Site:	The Nelson Hotel, 61 Pier Road, Littlehampton
Status:	Full Planning Application
App. No:	LU/324/18/PL
By:	D. Edwards
Date:	21 st February, 2019

1	Overview:	• Demolition of existing hotel to provide a new hotel with 14 keys. • Increase in plot coverage and a 21% increase in gross floor area. • Additional floor to provide a restaurant, bar and terrace.
2	Height:	4 floors/ 14.95m
3	Parking:	None proposed
4	Design intent:	• Striking elevations to increase awareness. • Maintain footprint and height of consented scheme. • Restaurant located on the corner to be further from neighbouring properties and maximise views and visibility. • Services to the rear. • Limited side openings to the east to maintain privacy of adjacent dwelling.

DRAWING TITLE
Site & Block Plan

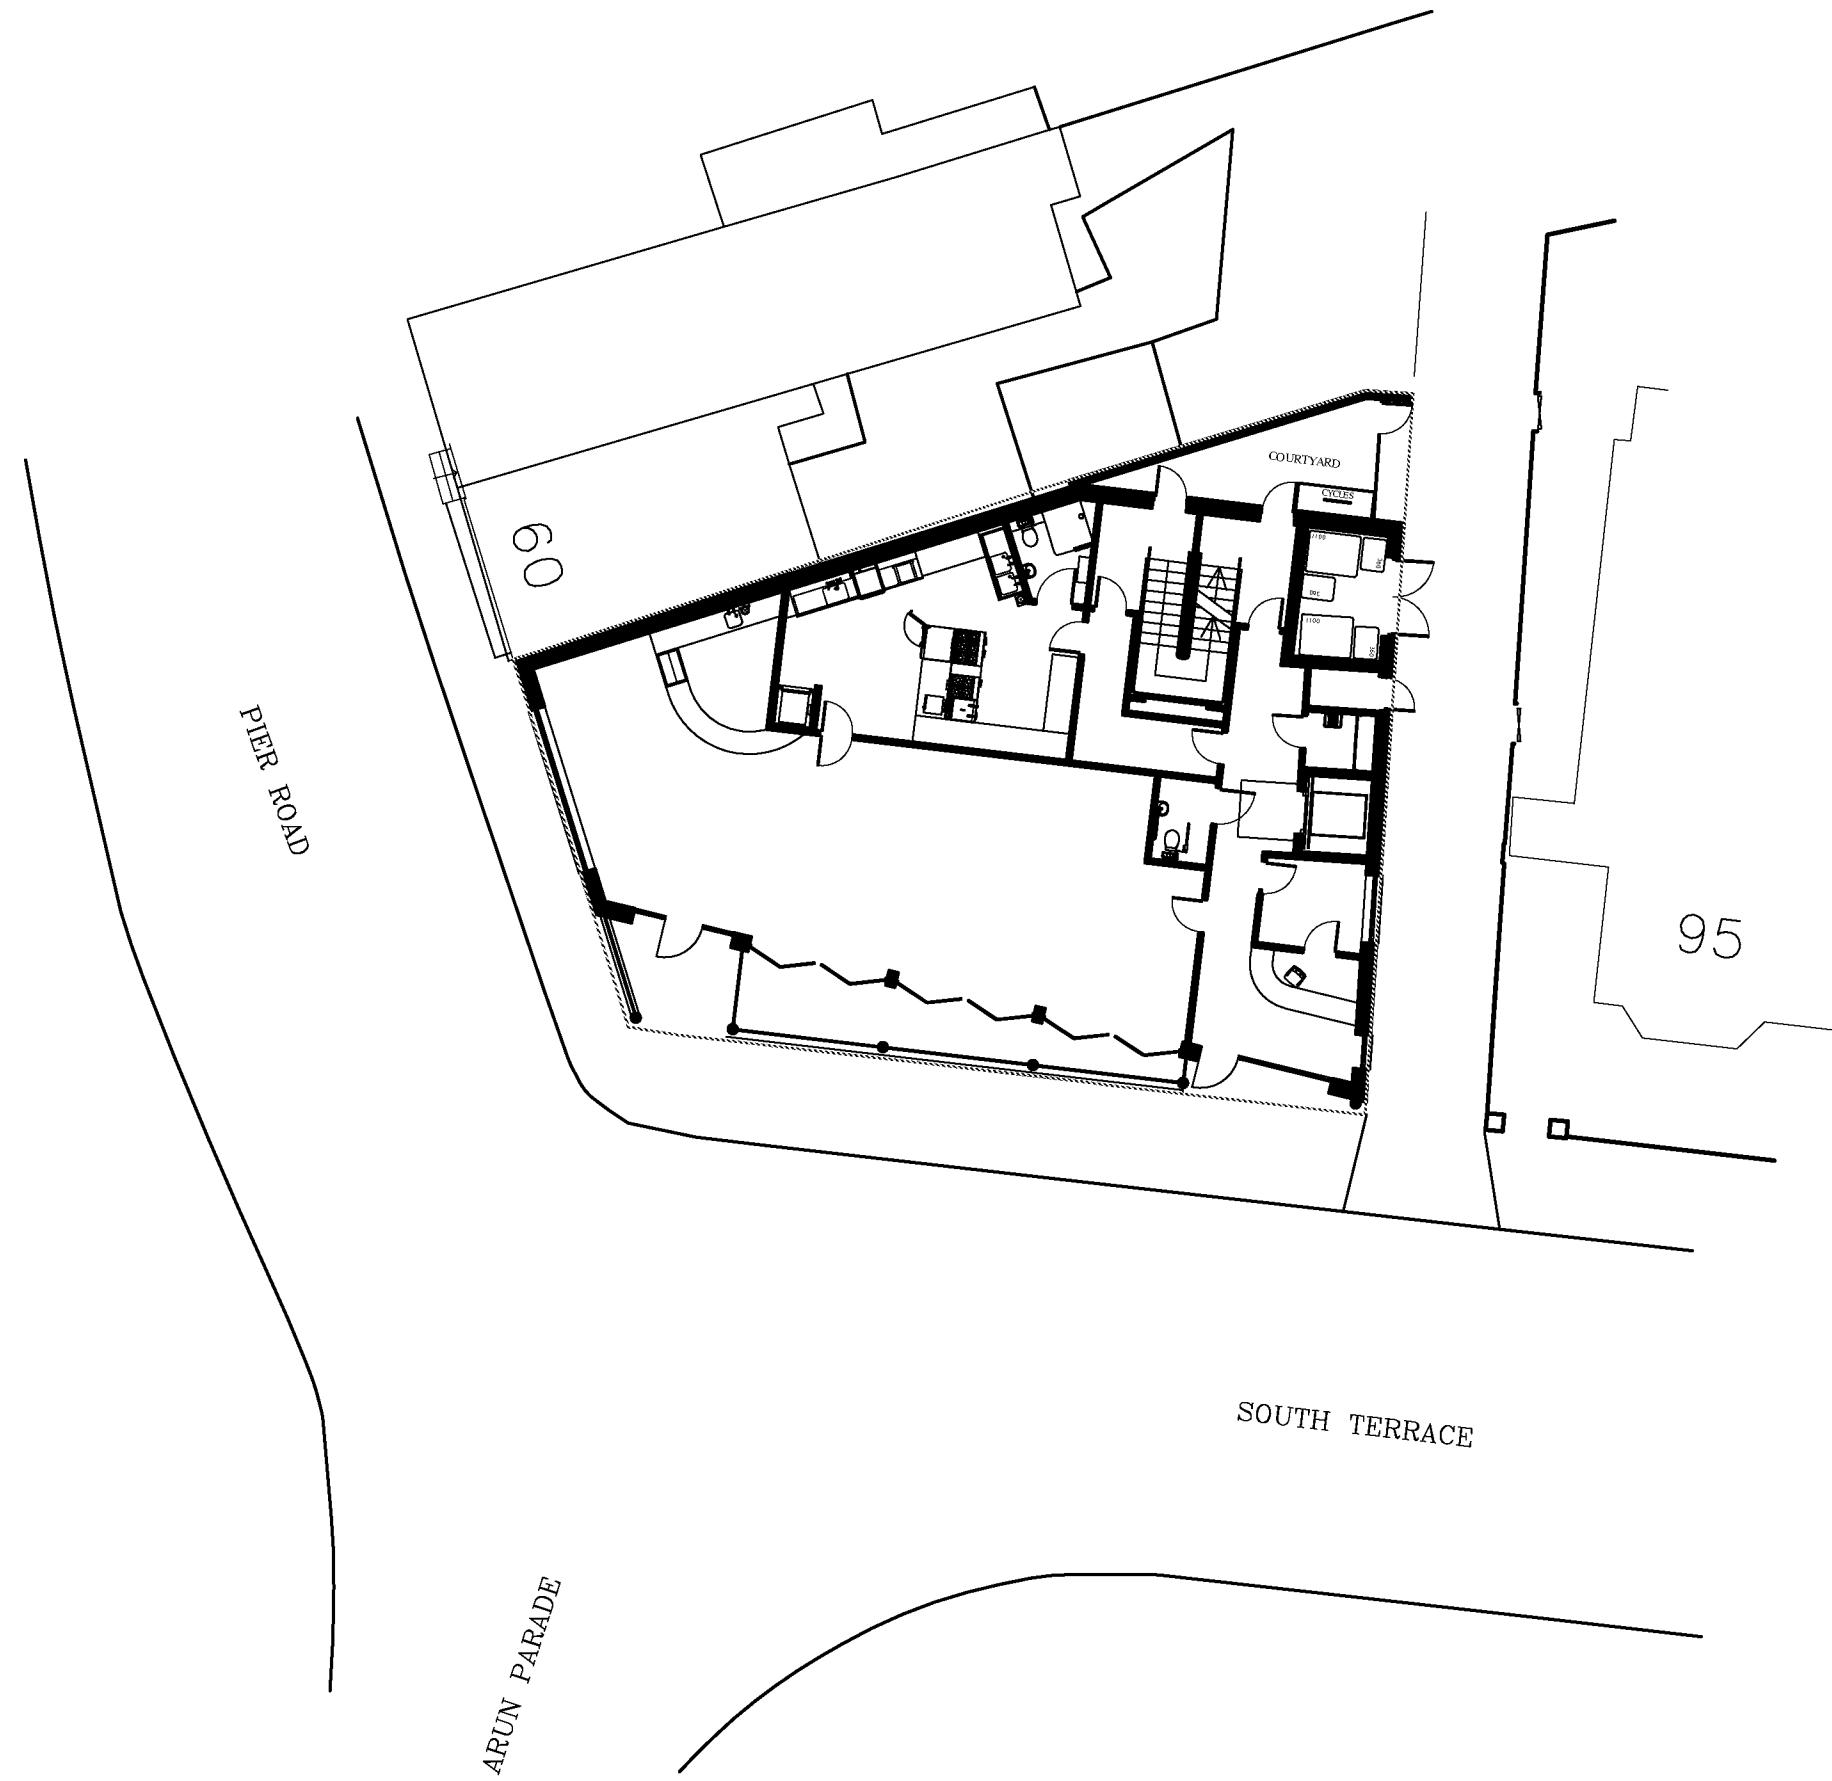
1.4	Through removing the external stair and extending further to the front and rear of the approved building line, the proposed footprint would almost occupy the full site. It is noted that the recessed ground floor and the roof terrace are intended to provide a degree of external area for guests. However, there is a concern that the rear courtyard will be insufficient for emergency access, storage, loading and servicing without spilling onto the private road.

1.5	By extending to the boundary on South Terrace, the proposed scheme involves the removal of a slight return in the existing building line. This return is quite significant – it creates a semi-private area for access and a widening to the private alley for visibility. Principally, it is also marries with the building line of South Terrace to open a long view from the end of Pier Road and create the impression of a gradual reduction in height to the waterfront when approaching from South Terrace.

However, the scale of this appears to accommodate 2/ 3 bicycles and given the location of this between the fire escape and the private road, there is a concern that any clutter in the courtyard will negatively impact means of escape – particularly given the proposed increase in the number of keys and roof bar/ restaurant.

two important street frontages.
3.2	Consider the proposed building line in relation to that of South Terrace – any extension beyond this has a greater visual impact on heritage assets and views towards the waterfront.

3.4	Consider reducing the overall footprint to maintain external area for services, storage, access and means of escape.
3.5	It is noted that the proposed panels were selected to reflect natural tones at the waterfront and while this is an interesting concept, given the sensitive location of the site, it would be more applicable to integrate with the existing built form context. In this respect, the use of similar forms, materials and tones of existing buildings within the area of special character and the conservation area would be welcomed.
